Ref: D2012/76601

Horsley Drive Business Park – State Significant Development (SSD-5169)

3 September 2012

**EROSION & SEDIMENT CONTROL PLAN**  
1:2000

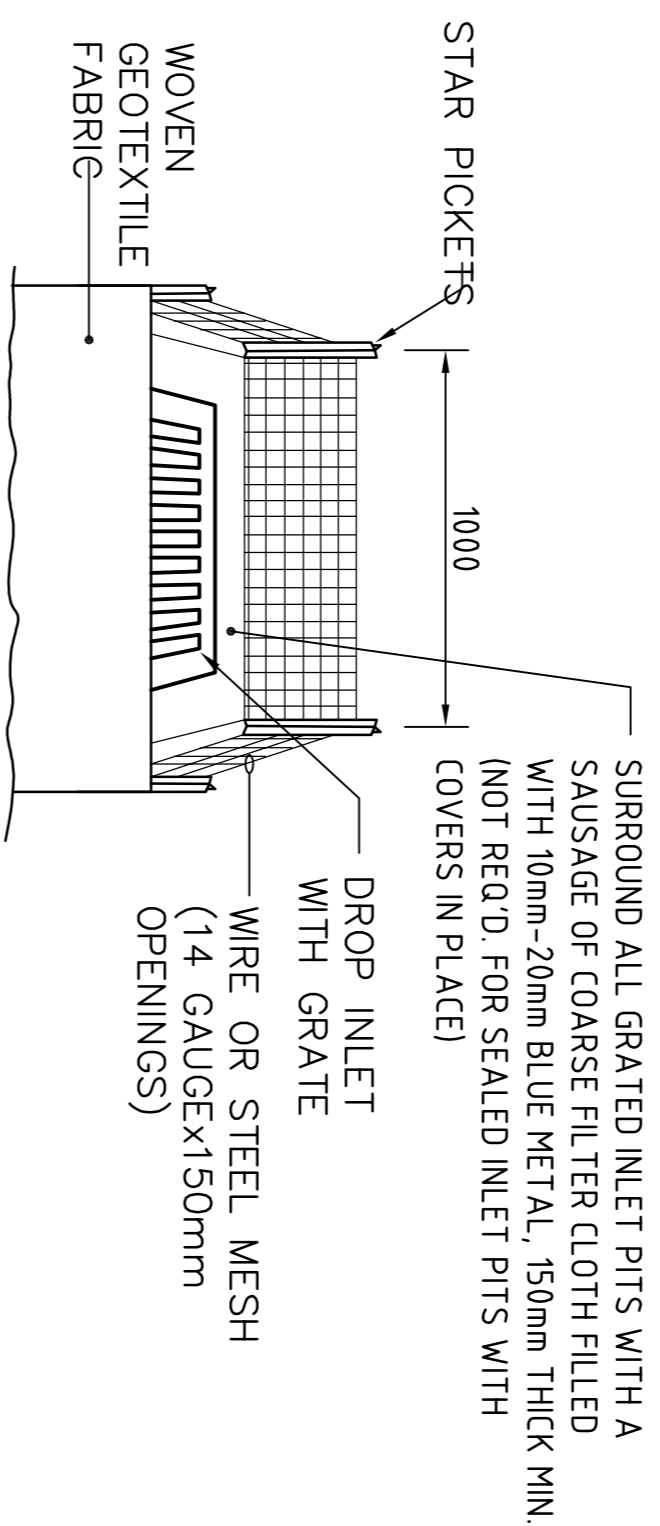
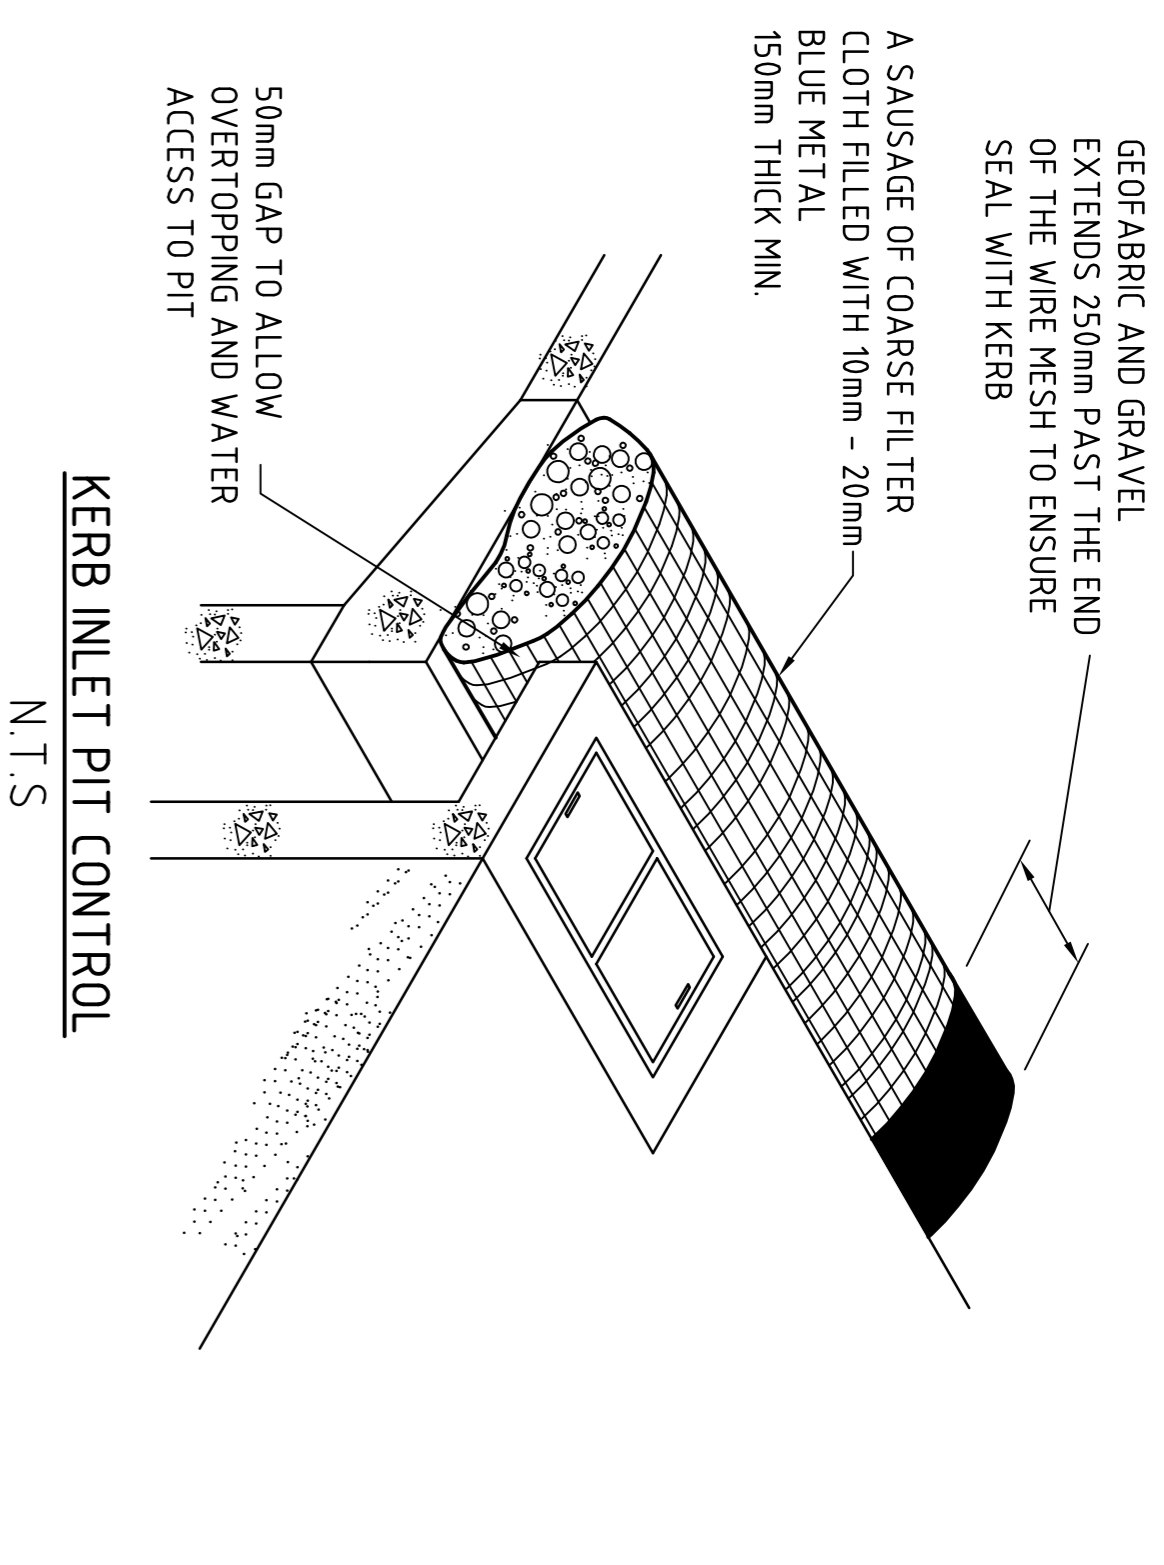
The Erosion and Sediment Control Plan shows a silt fence is proposed around the boundary of the site, including the boundary along the Upper Canal corridor to prevent sediment entering adjoining lands. As the works are occurring downslope of the Upper Canal, these controls are considered sufficient to prevent any impact on the water supply infrastructure.

EXISTING CATCHMENT PLAN
SCALE 1:2500

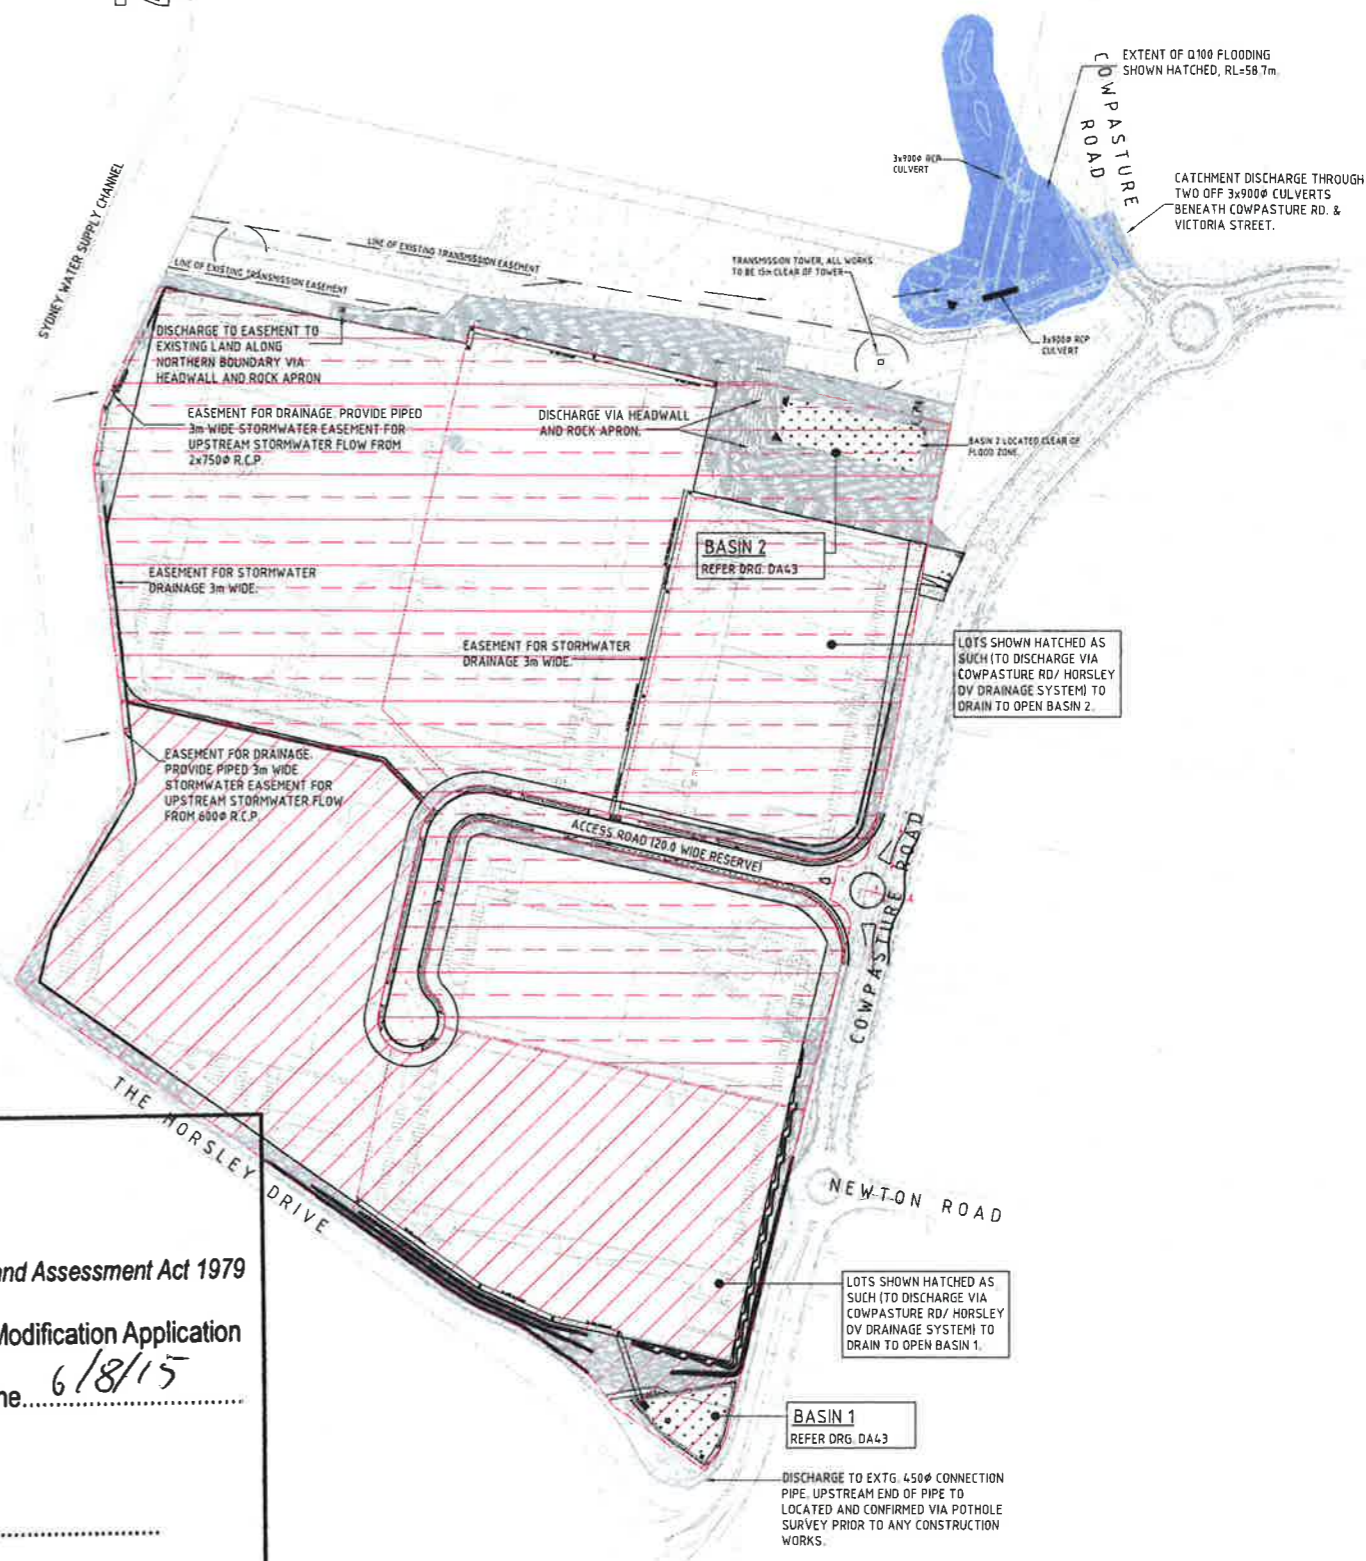
The Upper Canal is upslope of the development site and is therefore unaffected by stormwater flows from the site. The subject site is affected by overland flows emanating upstream of the Upper Canal corridor from catchments 2a and 3a (shown in the Existing Catchment Plan in Appendix 7).

The EIS considers the proposed piped stormwater drainage easement is sufficient to carry flows from the southernmost external catchment (2a) because flows from that catchment "will be blocked from entering the site by the Upper Canal so only minor flows are required to be allowed at this location." (page 14 Civil Engineering Report Appendix 6).

This statement is incorrect. Water is conveyed from the entire western side of the Upper Canal across the corridor and is discharged onto the subject site. There is also stormwater run-off from the corridor itself discharged onto the subject land. This stormwater system has been in place since the Upper Canal was constructed in the 1880s.

As stated in Condition 5 above, the stormwater management system should ensure that it makes allowance for all flow emanating from land to the west of the Upper Canal and from the corridor itself. This will require the proponent to reinvestigate whether the proposed piped stormwater drainage easement will be sufficient to accommodate those flows.

5. Stormwater systems shall be designed to accommodate and not impede upstream flows from any systems that convey stormwater across, along or under the Upper Canal. The stormwater management system should ensure that it makes allowance for all flow emanating from land to the west of the Upper Canal and from the corridor itself. The SCA shall be provided with details of these stormwater systems located along the SCA boundary before such works commence.
